Date: 09/02/2025

Re: **Oversized Turndown Footing Specifications**
Location: Lot 83 Birchwood Trails (207 Rockwood Dr. Fuquay-Varina, NC)
JDS Project No.: RDU2509123
Date of Inspection: 09/02/05

TURNED-DOWN CONC SLAB FOOTING 1/2" = 1'-0" **1**

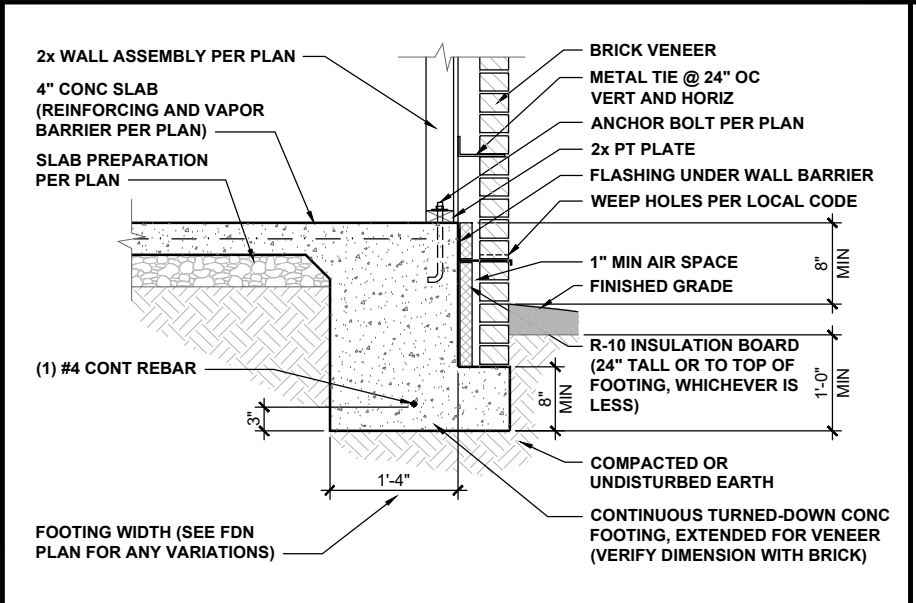
The client requests an oversized footing specifications for the foundation at the rear. The max height of the grade measures approximately 44" to the subgrade.

Based on our observation and review, the below specifications are for 4' maximum unbalanced fill and 6' maximum unbalanced fill.

4' Maximum unbalanced fill:

1. The turndown footing will have maximum 48" unbalanced fill, with minimum 12" below grade.
2. Maintain turndown thickness consistent with the plans.
3. Install (1) #4 rebar continuous centered at the bottom of the footing.
4. Install (1) vertical #4 rebar spaced 24" on center with 3" cover from the edge. Rebar will be bent 90° and extend minimum 3' into the mid-depth of the slab. Additionally, install horizontal #4 rebar spaced 24" on center, in the footing and in the slab, tied into the vertical rebar.
5. **Ensure that footing prep is approved prior to placement of minimum 3000 psi concrete.**

6' Maximum unbalanced fill:

1. The footing will be constructed as a stem wall.
2. Excavate a 4' wide by 12" thick footing with 8" toe projection. Bottom of footing will be 2' below finished grade, with 12" of soil over the toe at finished grade.
3. The footing will have (3) #4 rebar evenly spaced in the footing with 3" clear cover from the bottom.
4. Install a vertical #4 rebar spaced 16" on center with an 8" hook at the bottom, and 24" projection into the center of the 8" thick CIP wall (see step 6.)
5. **Ensure that footing prep is approved prior to placement of minimum 3000 psi concrete.**
6. Form an 8" thick CIP wall with 8" projection from the end of the toe.

7. Splice in vertical #4 rebar spaced 16" on center into the rebar noted in step 3. The rebar will extend to the top of the wall and bend 90° into the mid-depth of the slab. Additionally, install horizontal #4 rebar spaced 18" on center into the wall, tied into the vertical rebar.
8. **Ensure that wall prep is approved prior to placement of minimum 3000 psi concrete.**
9. The vertical rebar noted in step 7 will be 90° bent into the mid-depth of the slab and be tied into a 16" x 16" rebar grid that extends a minimum of 3' over undisturbed soil. All disturbed soil behind the wall shall be removed and the wall should be backfilled with clean washed crushed stone.
